RE: Response To ACP 30 September 2026

The enclosed technical note is a response to the letter from the ACP dated 30 September 2026.

RESPONSE TO ACP DATED 30 SEPTEMBER 2026

Figure 8.34 CALPUFF Modelling Grid For The Ringaskiddy Resource Recovery Centre, Ringaskiddy, County Cork

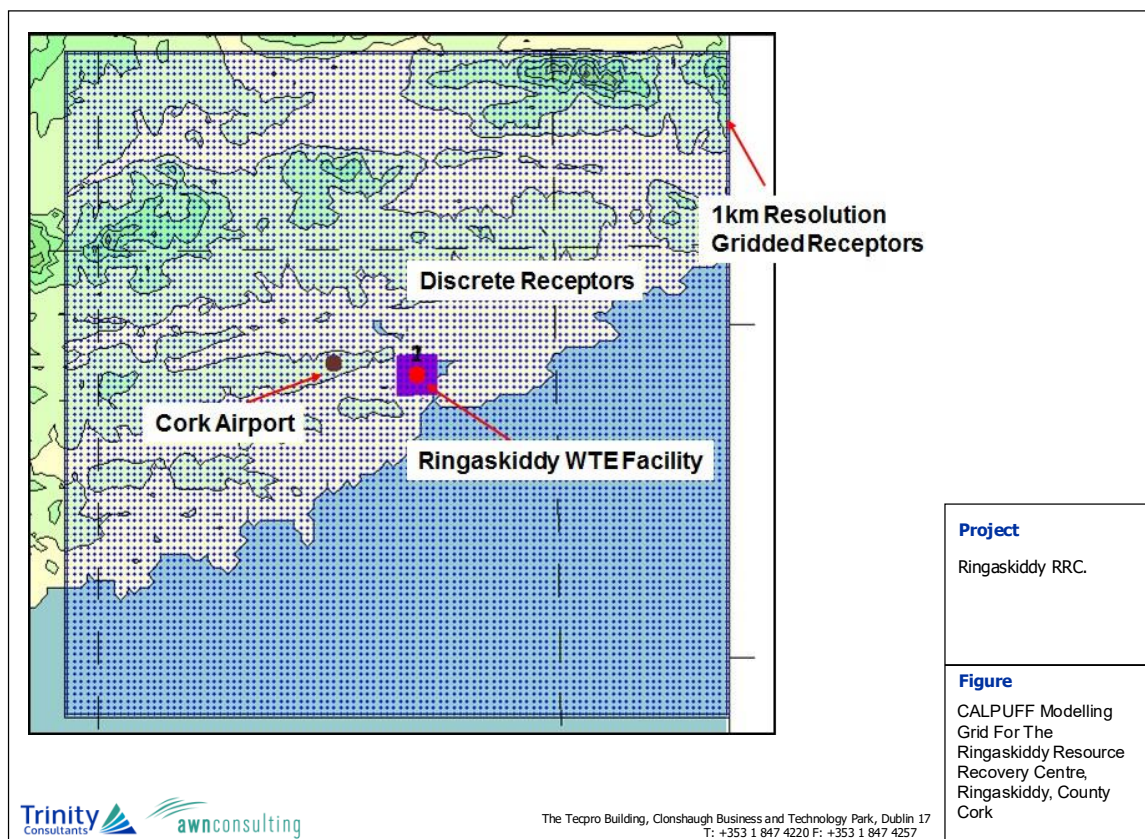
- 3. Following receipt and consideration of your response to item 5 of the further information request, you are requested to clarify the level of consideration given (if any) to coastal fumigation and complex local meteorological conditions in the dispersion modelling study, in line with the advice and requirements of EPA guidance 'Air Dispersion Modelling from Industrial Installations Guidance Note (AG4) (2019).***

“As shoreline fumigation was also raised as a possible concern in the previous application and AERMOD does not have the capability to model this phenomenon, CALPUFF (version 6.42) was selected as the most appropriate model which could assess all possible meteorological conditions within the one air dispersion model with the modelling domain shown in Figure 8.34.”

As outlined in Section 8.6 of Appendix 8.1 of the EIS, detailed modelling of the facility was undertaken using the CALPUFF air dispersion model and the modelled results were compared to the ambient air quality standards. The modelling approach that has been undertaken is consistent with the requirements of AG4 (EPA, 2019). The conclusion of the assessment, as outlined in Section 8.6.3 of Appendix 8.1 of the EIS, was that all results are in compliance with the air quality standards including under coastal fumigation conditions.
